Memo.

Date: 3rd January 2011
To: Planning
Cc: -
From: Miriam Hill
Subject: S6/2011/2685/FP – 29-30 GREENFIELDS, SOUTH DRIVE, CUFFLEY
ERECTION OF TWO BUNGALOWS

SITE PLAN - scale 1:200

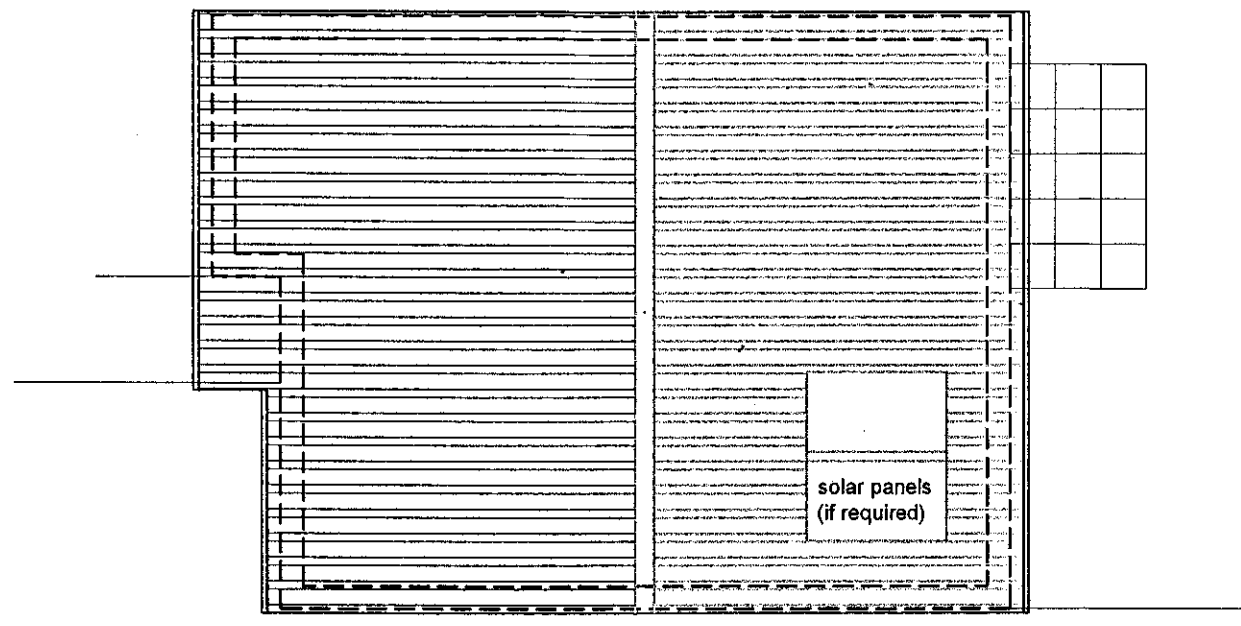
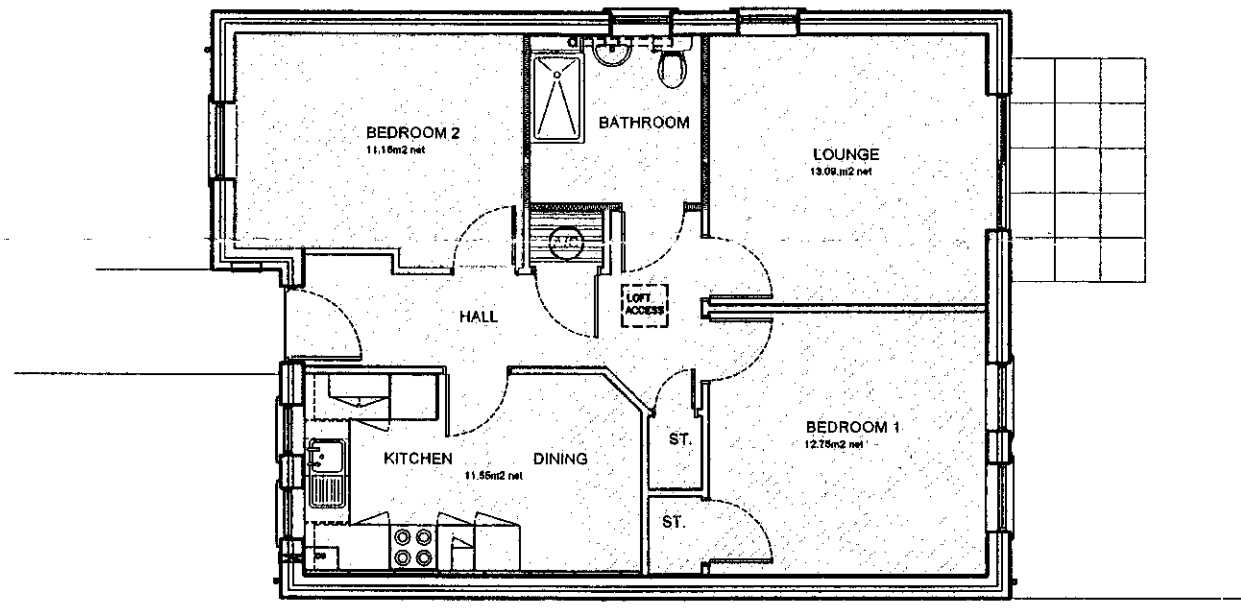
The site layout, in relation to the landscaping, appears to be unchanged from the previous application, S6/2010/0098/PA. There are no changes to my previous comments which I have included below.

The proposal is to erect two bungalows and create a landscaped seating area between them. This will require the removal of six trees and the remaining trees will have to be pruned. The trees which are to be removed are of mixed quality. The two semi-mature trees adjacent to 29 are the only trees which will be a loss to the site. However these trees are not sufficient quality to preserve or refuse the application. Although all the trees on site are relatively small or young, thought should be given as to how the materials and machinery are to access the working area. This may effect the trees not currently designated for removal.

As the new landscaping will be in a public place I think it would be appropriate for the Council to approve these plans. Details of species, size of planting material, density or numbers should be included. I would also suggest that it would be prudent to consider the boundary on the north of the site adjacent to the cycle store for some planting. This will help screen the new bungalow from the houses on South Drive and buffer the noise of the

school. Unfortunately as the schools access drive is over the boundary it would be inappropriate to suggest any trees but a hedge or a low maintenance informal shrubbery would be appropriate.

I recommend that should permission be granted a condition be that a detailed landscape plan be submitted for approval by the Council.
